OFFICIAL NOTICE OF DECISION

CITY OF ALBUQUERQUE
PLANNING DEPARTMENT
DEVELOPMENT REVIEW BOARD

3. Project # 1002567

ADVANCED ENGINEERING & CONSULTING LLC agent(s) for STEVE KIRK request(s) the above action(s) for all or a portion of Lot(s) 5-A-1, COLEMAN ADDITION (to be known as **HACIENDA DE LOIS SUBDIVISION**) zoned R-2 residential zone, located on 12TH ST NW, between MENAUL EXTENSION NW and LA POBLANA NW containing approximately 1 acre(s). [REF: 06DRB-00726] (H-13)

12TH ST. RIGHT OF WAY DEDICATION EXHIBIT

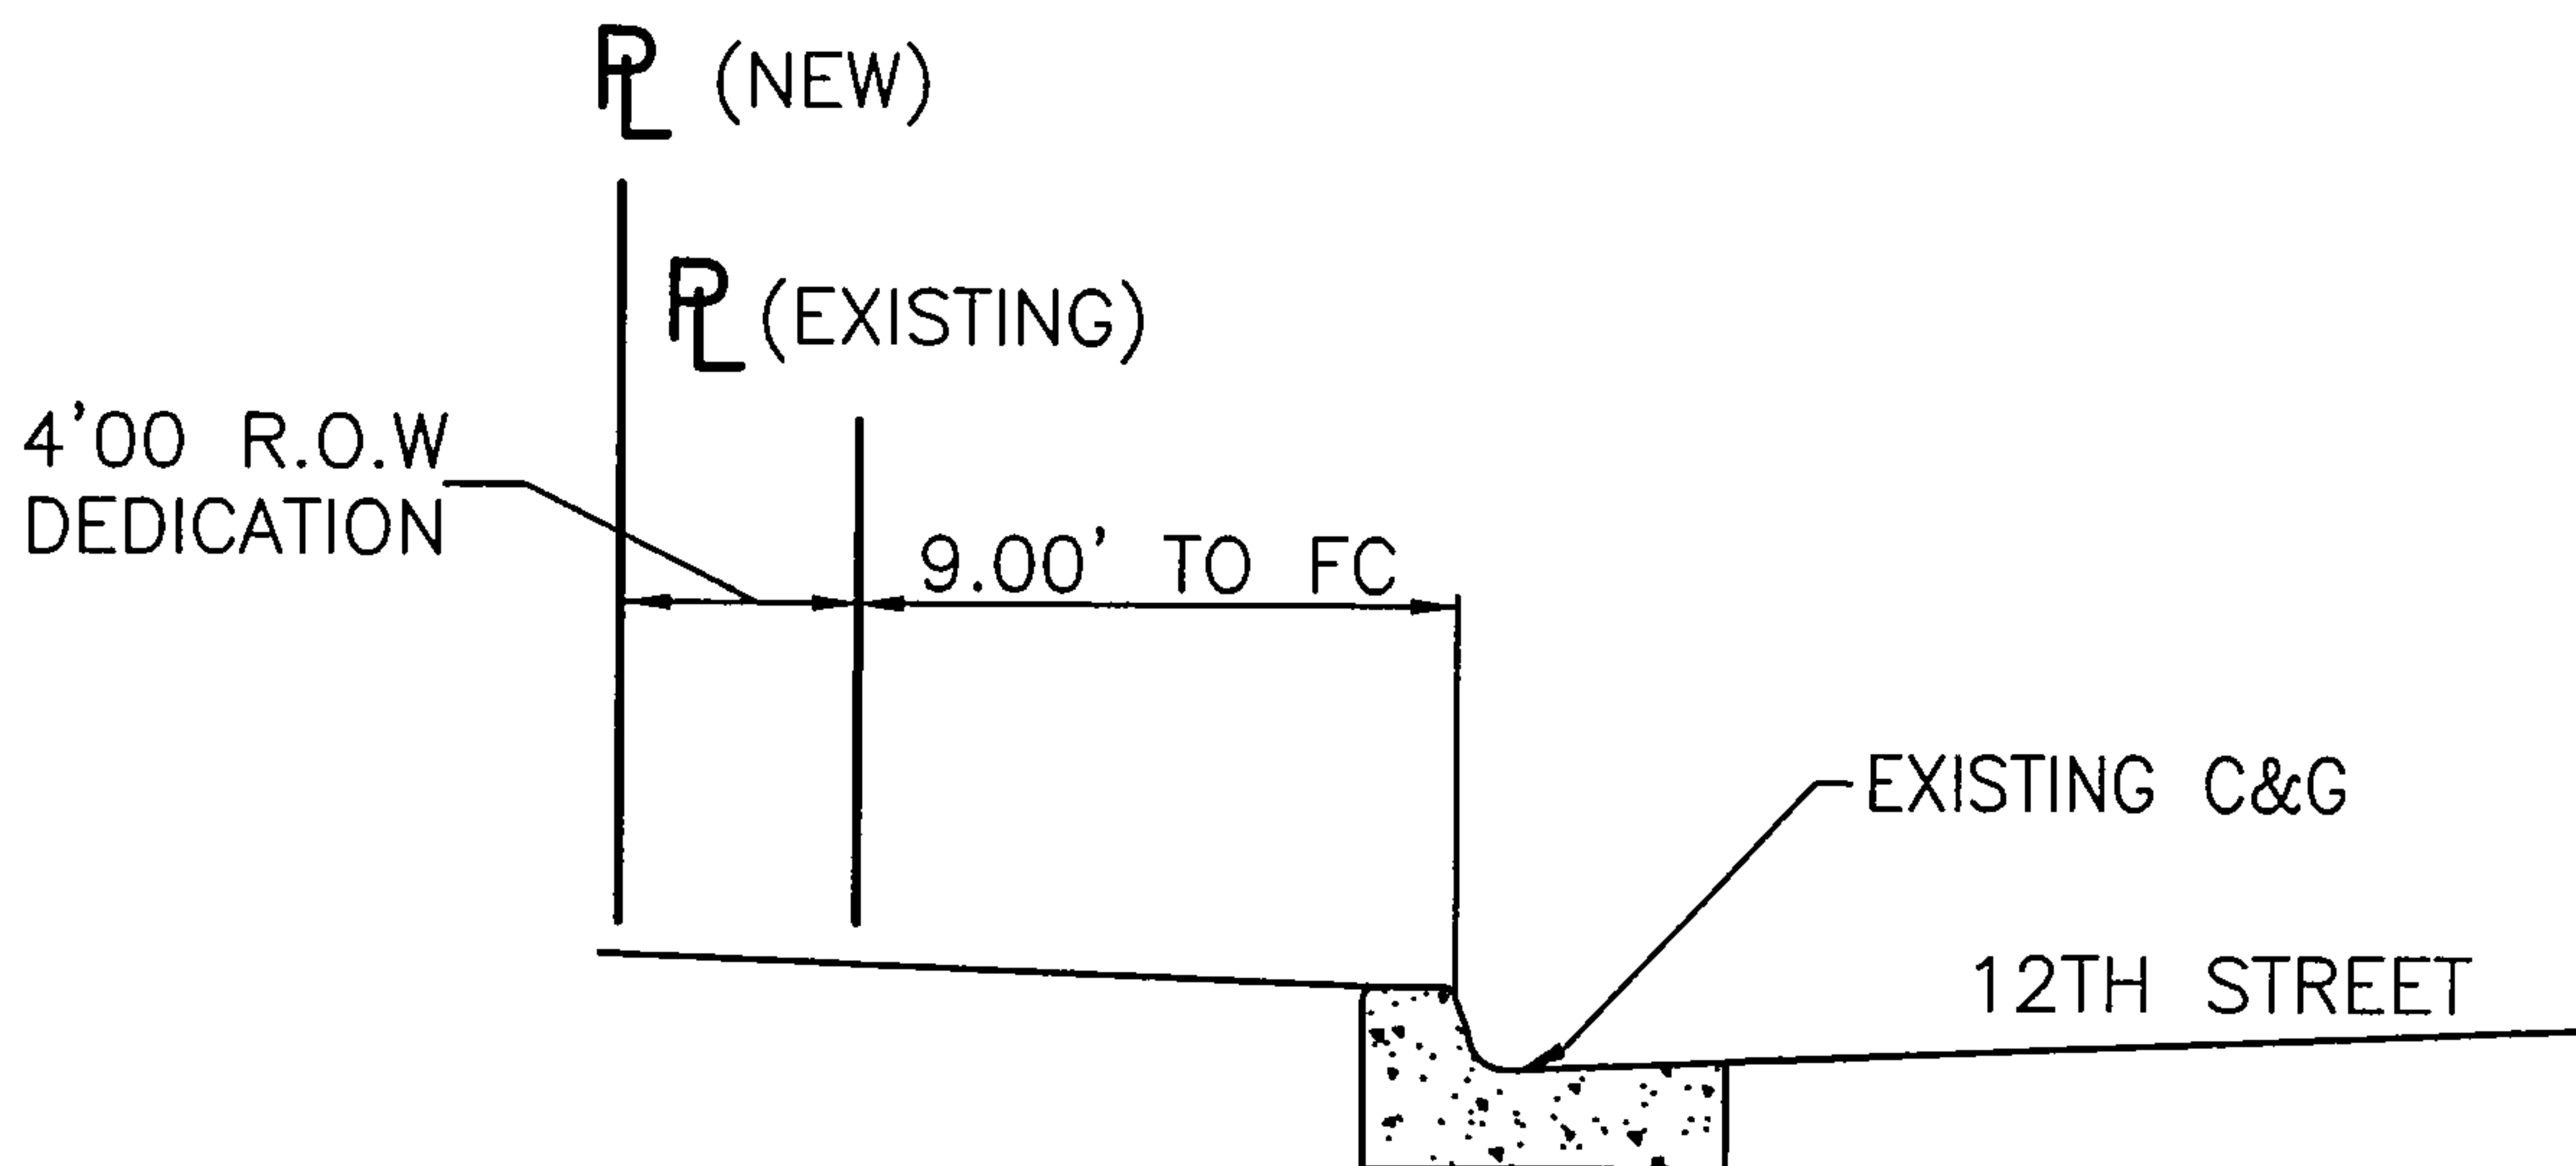
13-feet from face of curb to property line should be dedicated as right-of-way.

GARDEN WALL EXHIBIT FOR
HACIENDA DE LOIS SUBDIVISION
DRB-1002567

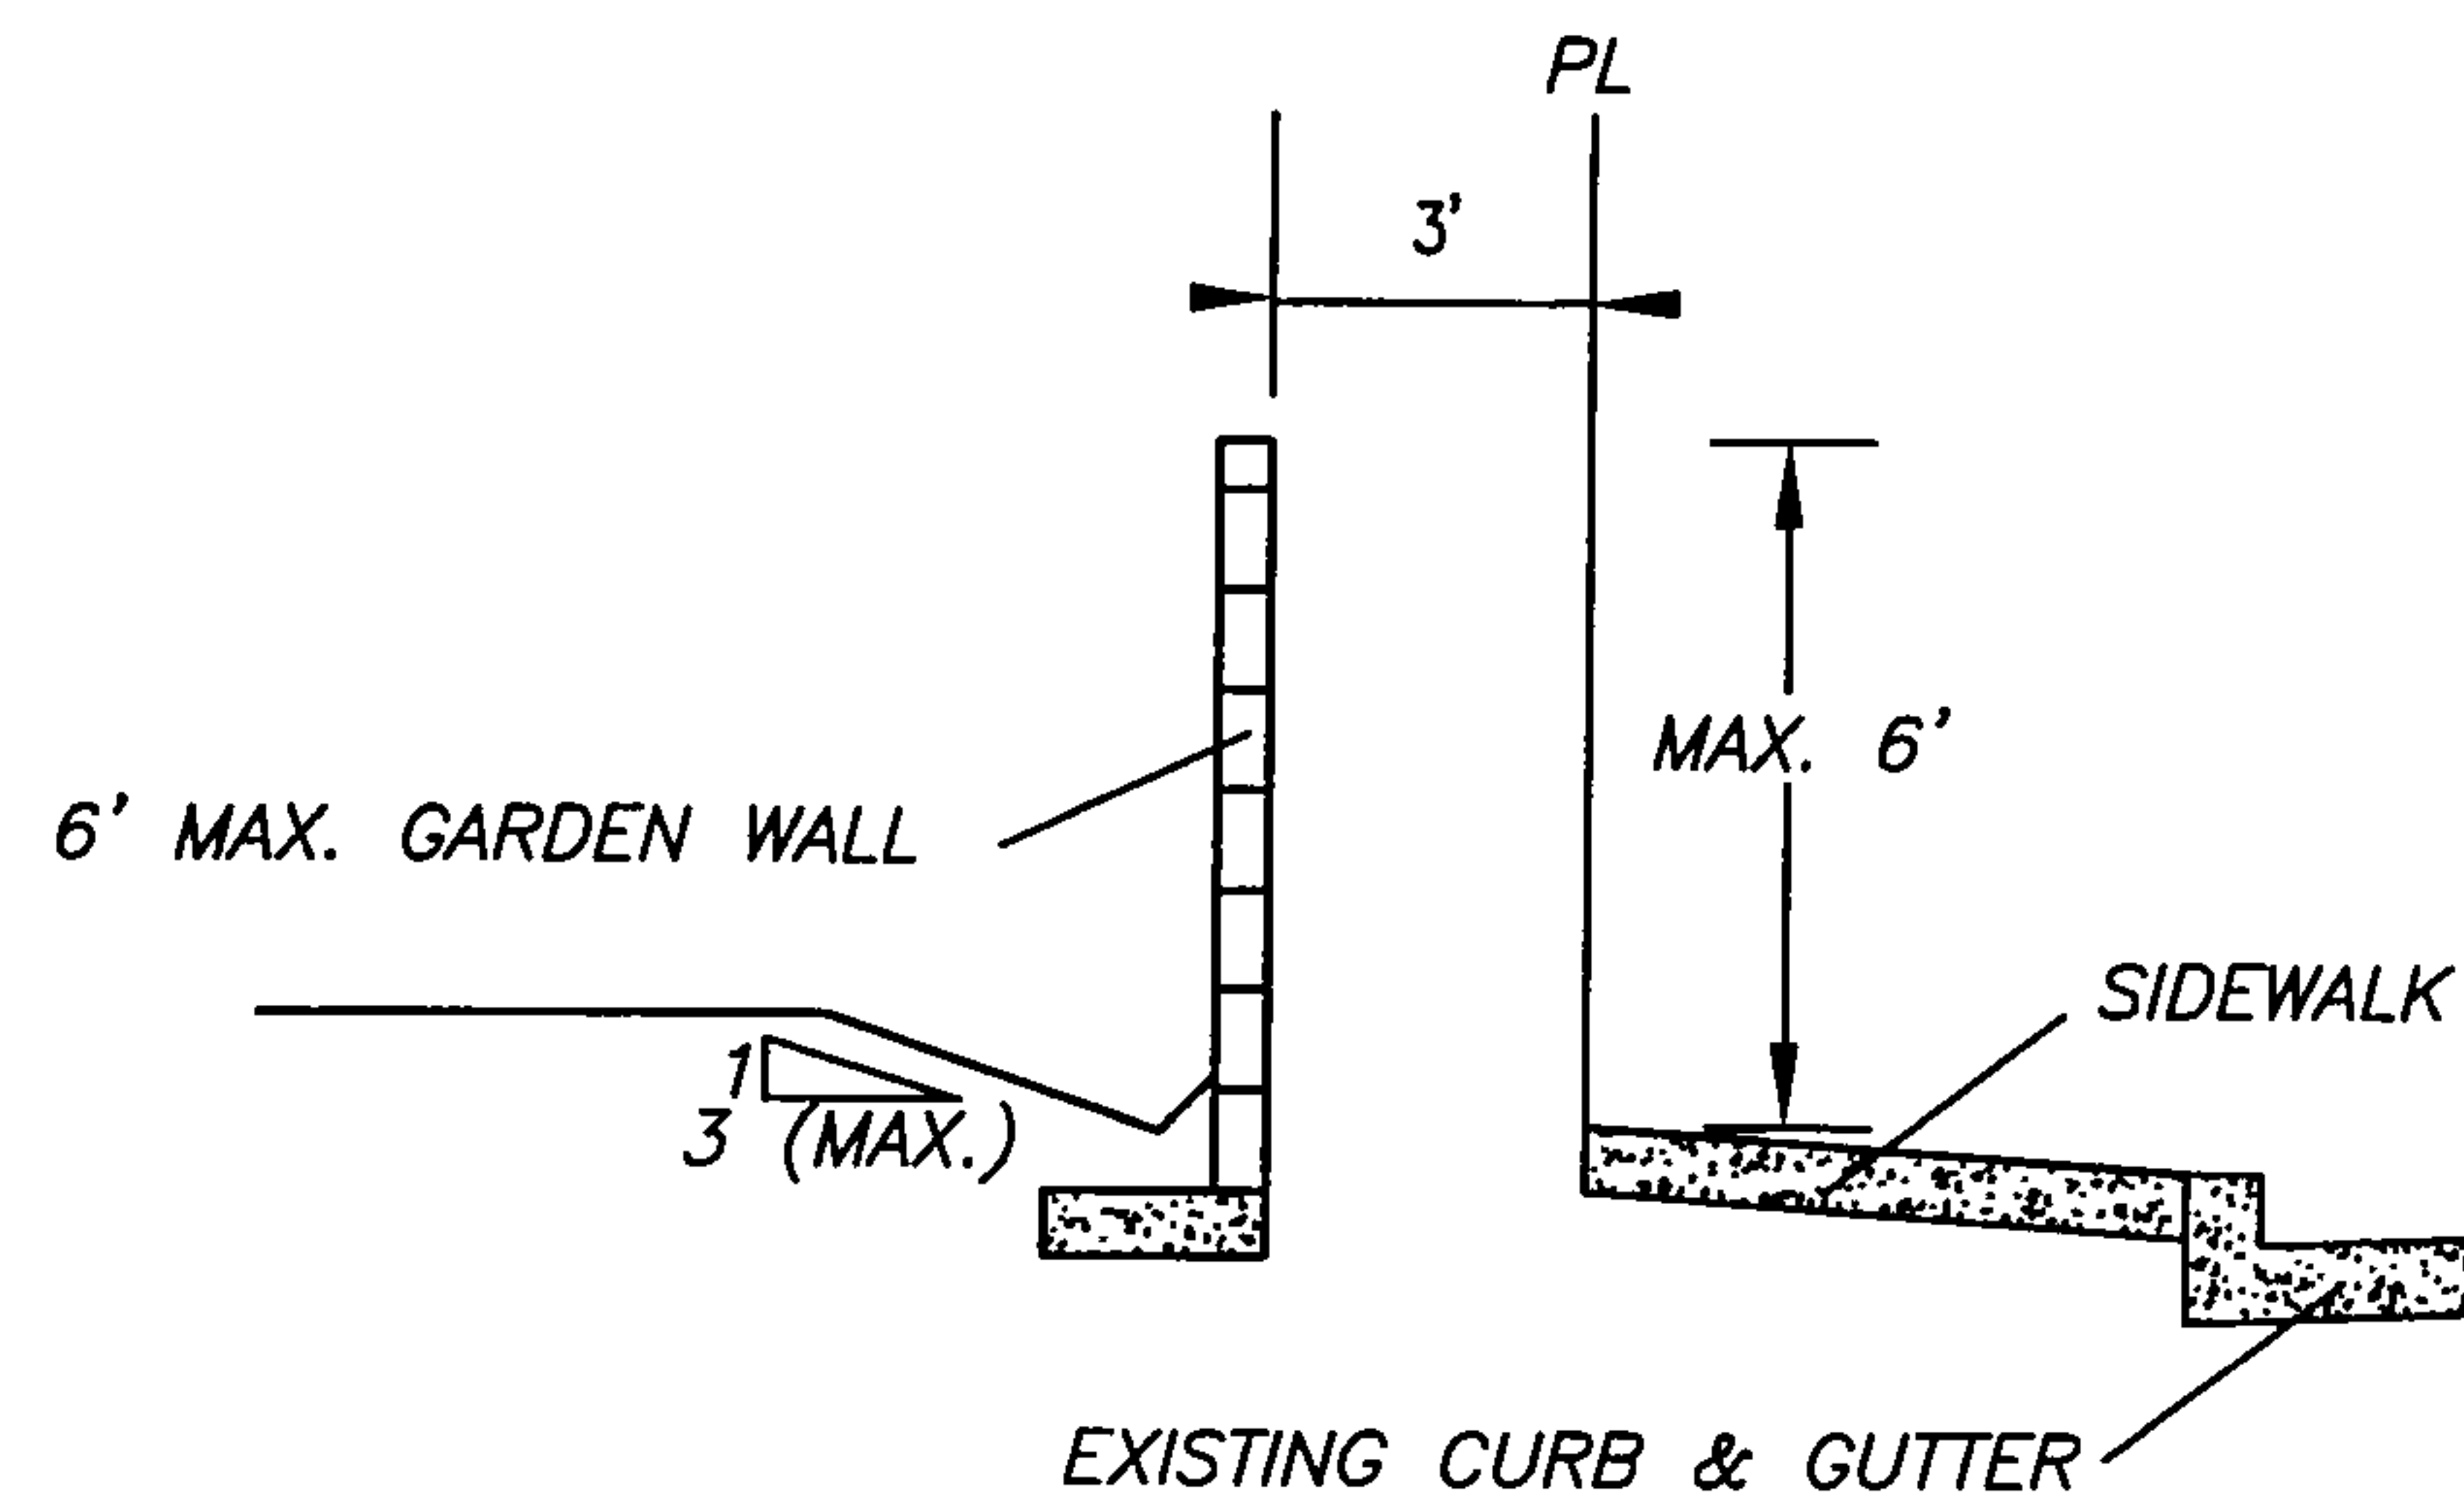
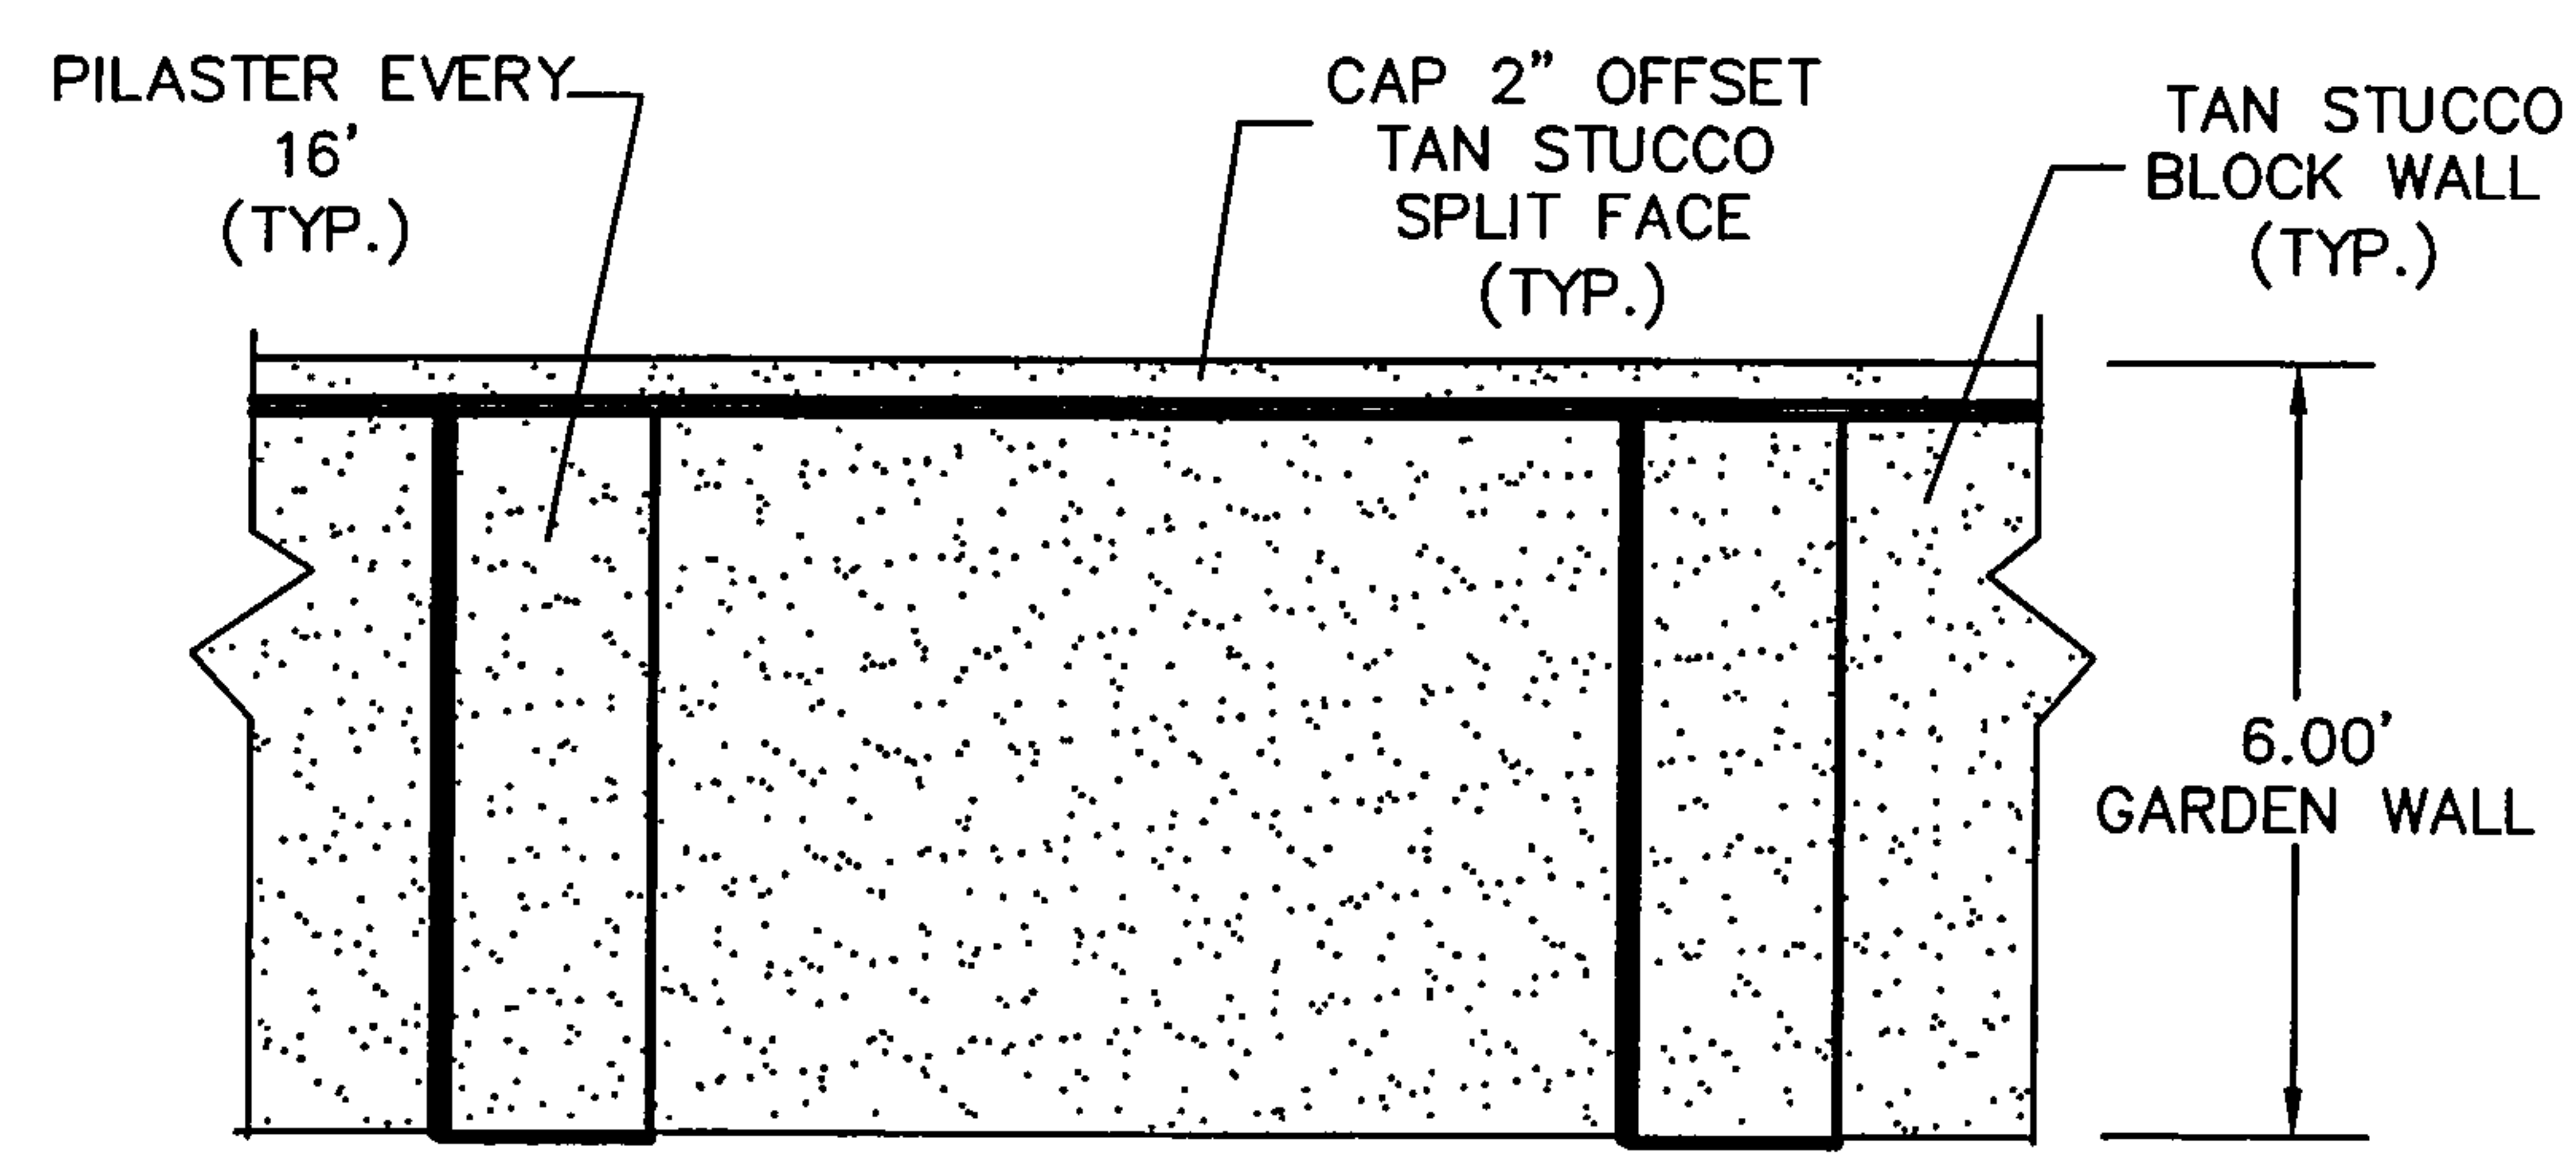
An improved wall design is needed,
